PLANNING CONSULTATION RESPONSE

Application No	2025/1032
Proposal	Single storey side extension and dropped kerb.
Address	102 Manchester Road, Thurlstone, Sheffield, S36 9QW
Date of Consultation Reply	11.03.2026
Consultee	Charlie Atkinson Design & Conservation Apprentice

PROPOSED PLANS & ELEVATIONS

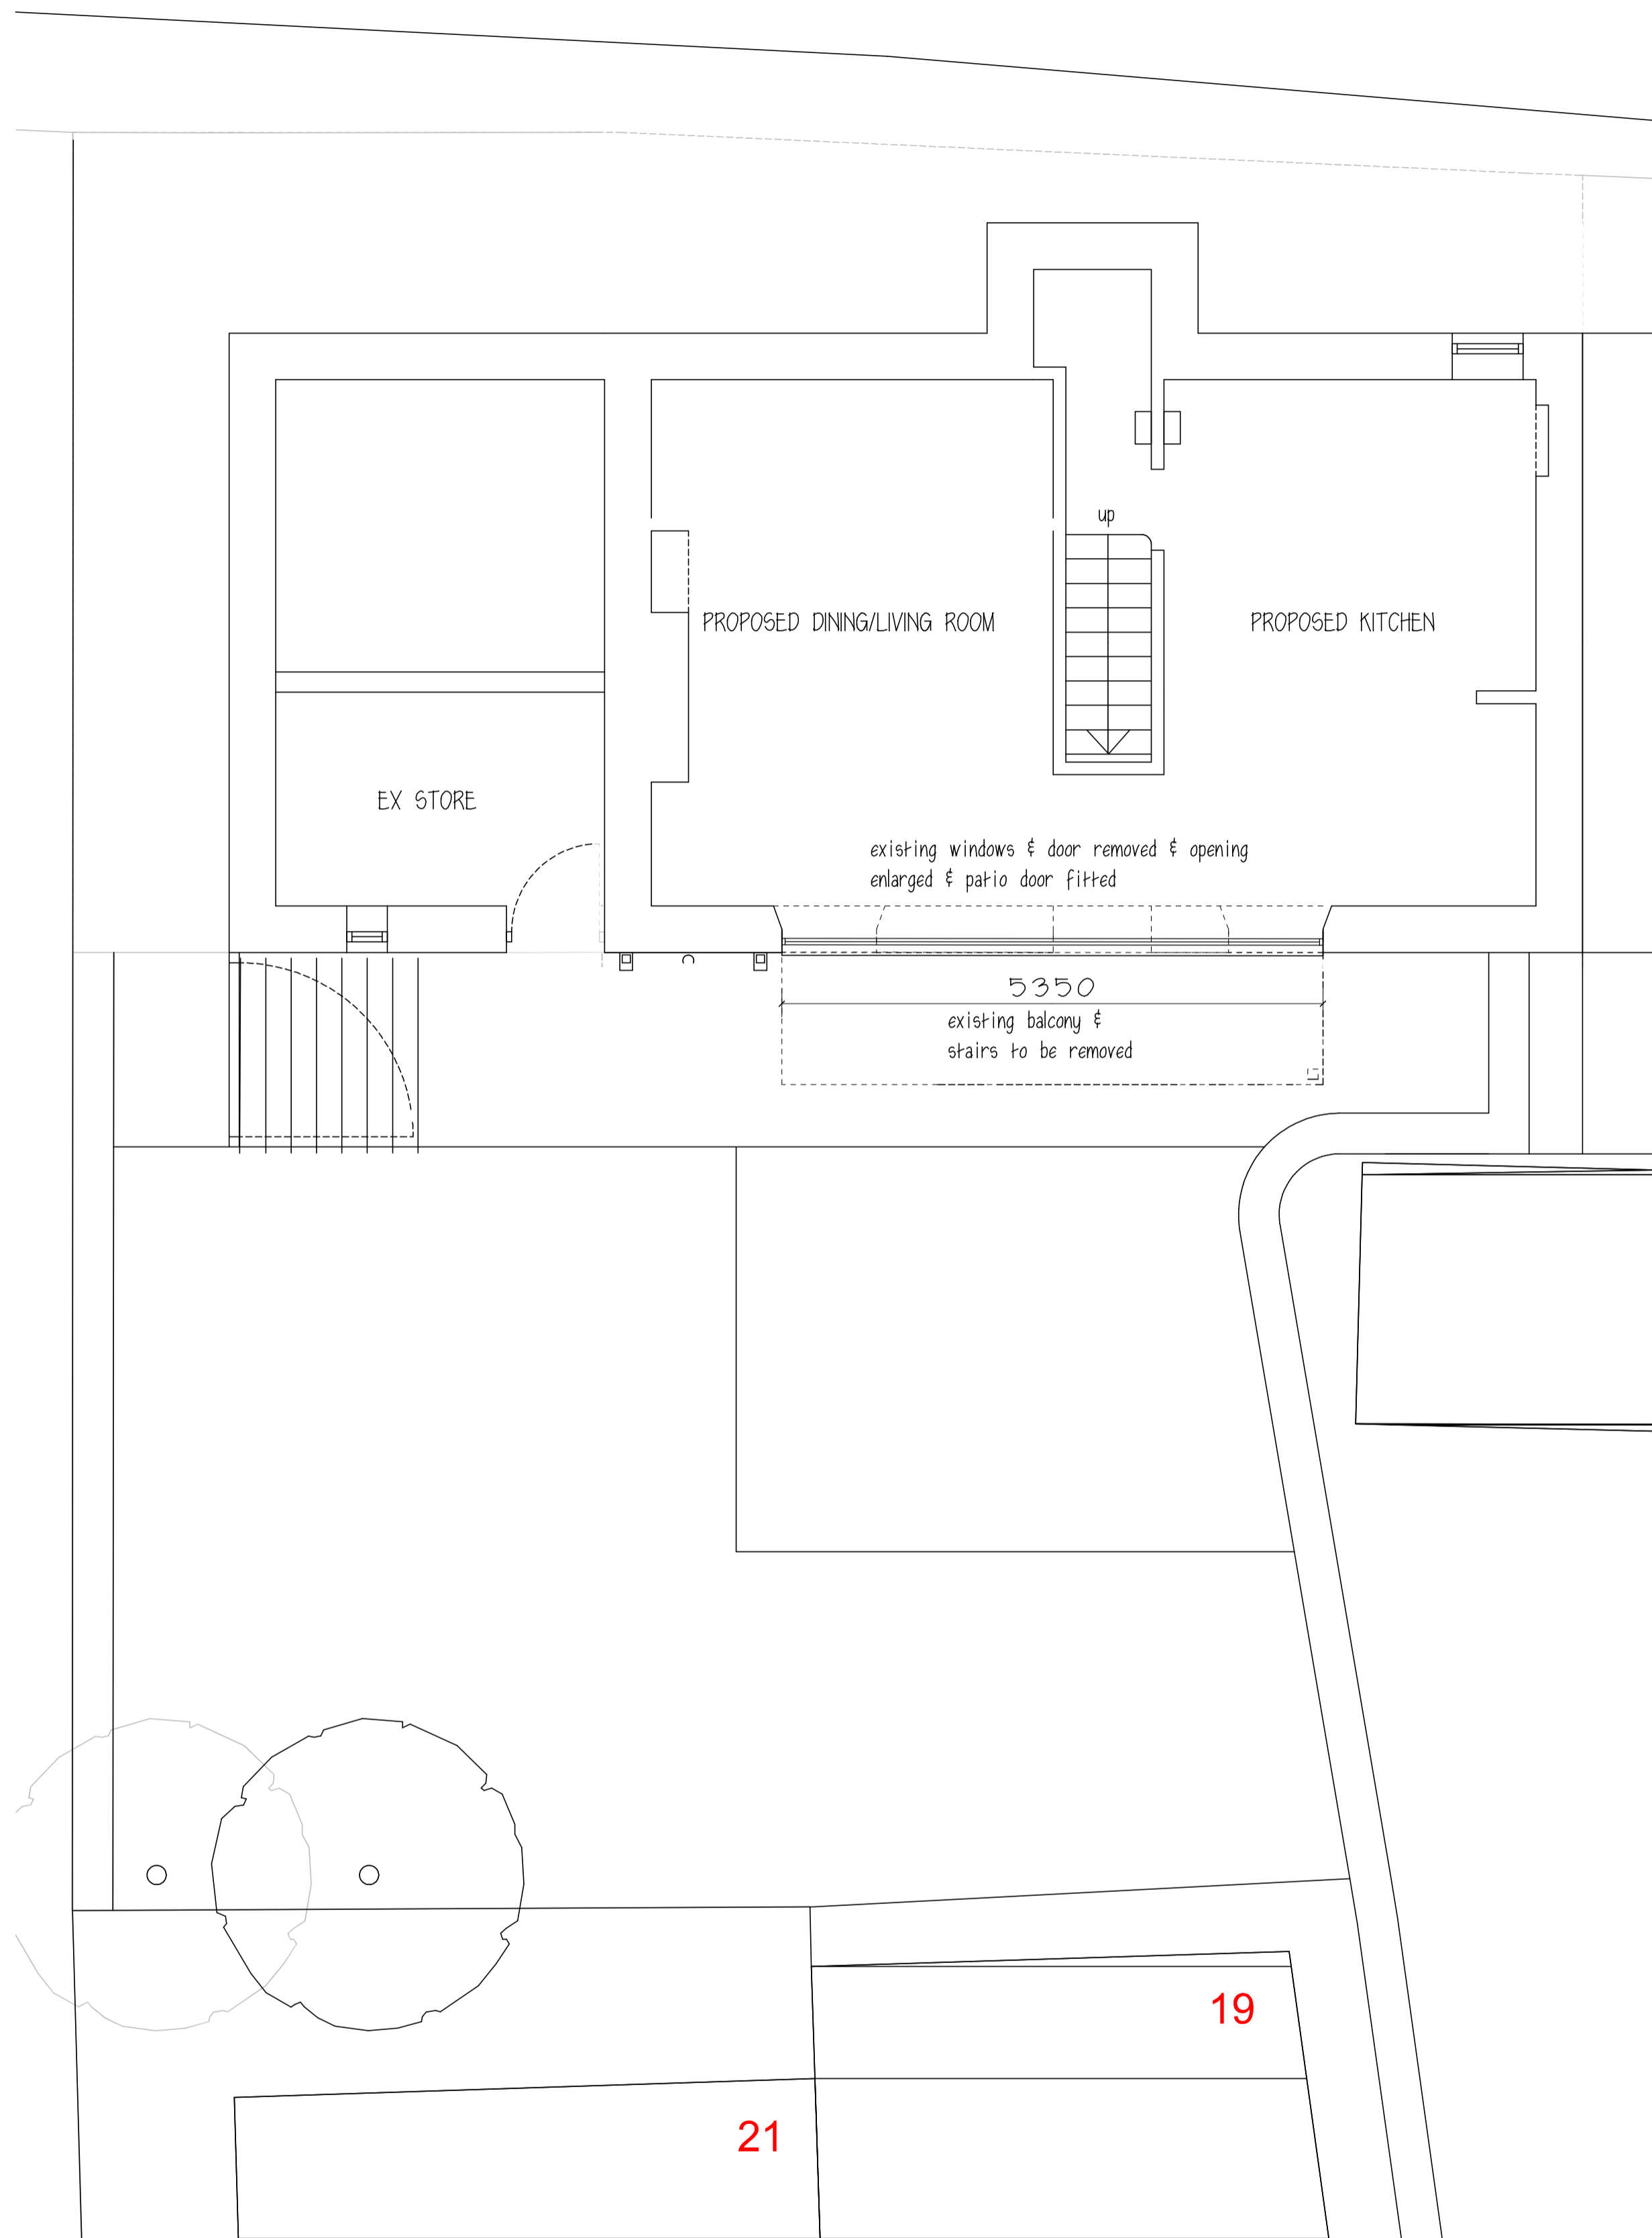
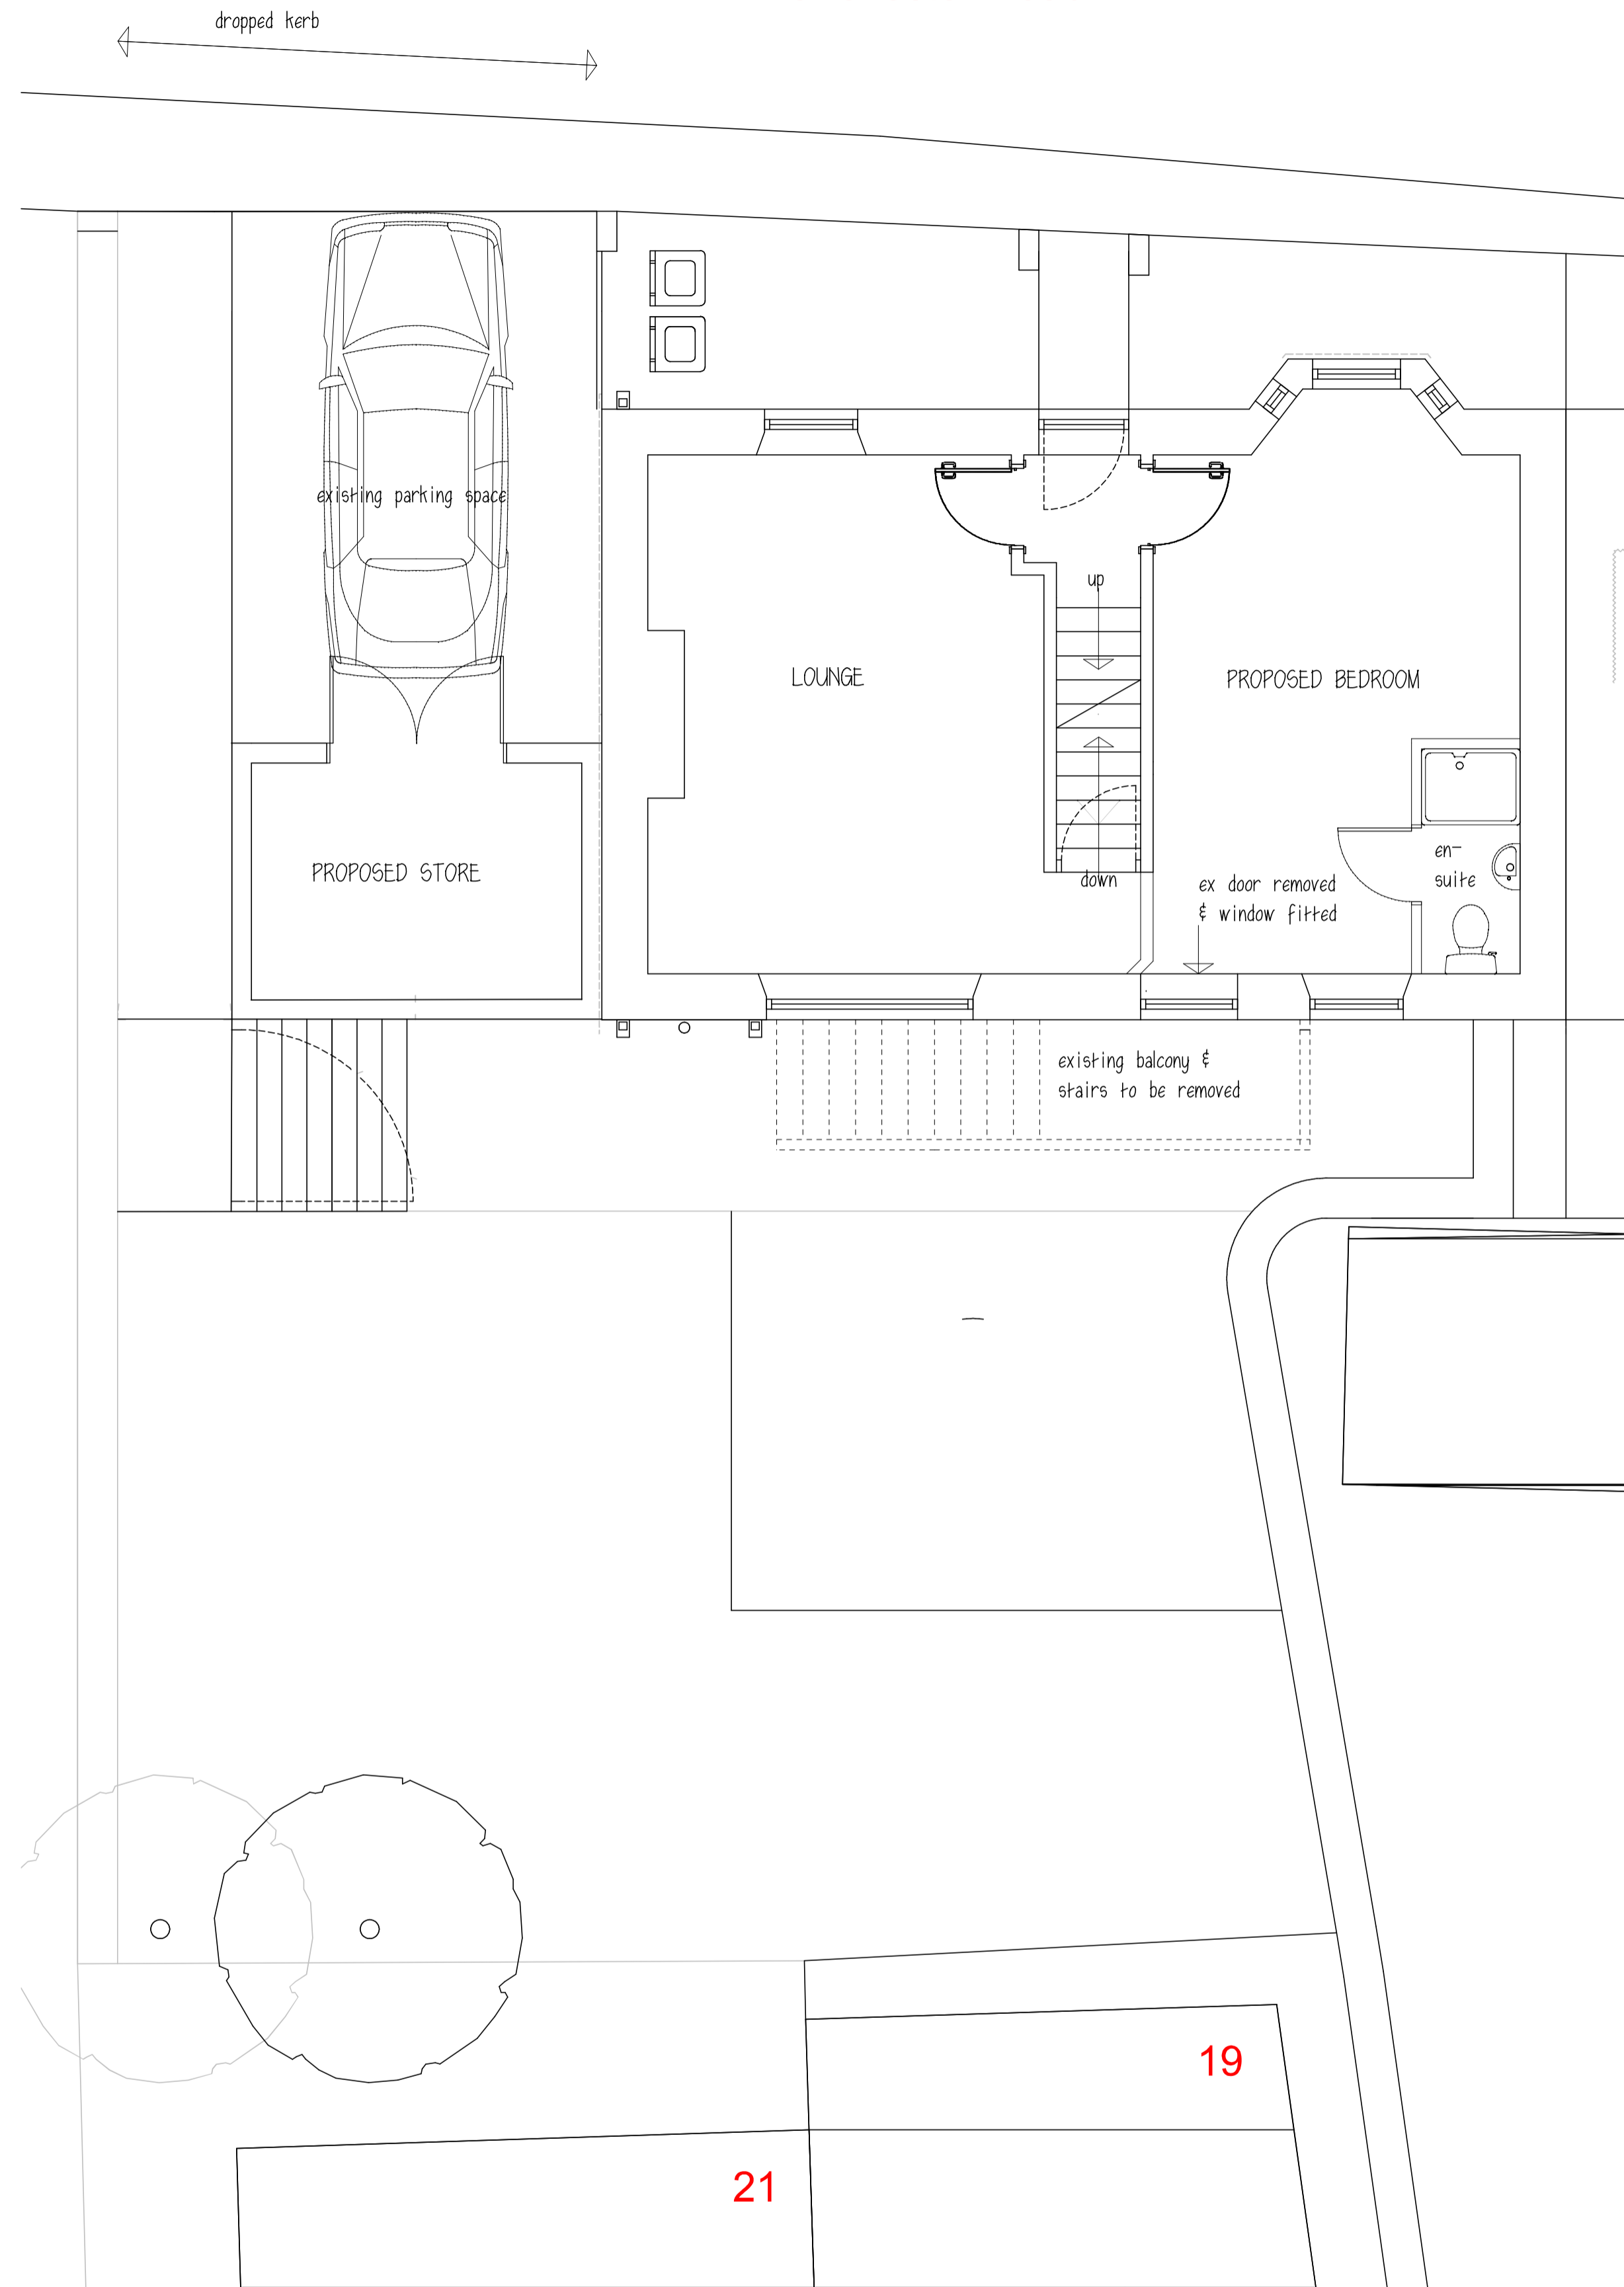
In principle, there are no significant conservation objections to the proposed works. However, in order to ensure that the development conserves the character and appearance of the building and the wider conservation area, the following conditions are recommended in relation to the proposed single-storey side extension:

- The facing stone shall match the existing building in terms of colour, size, type of stone, face dressing.
- The roof covering shall match the existing roof in terms of colour and appearance.
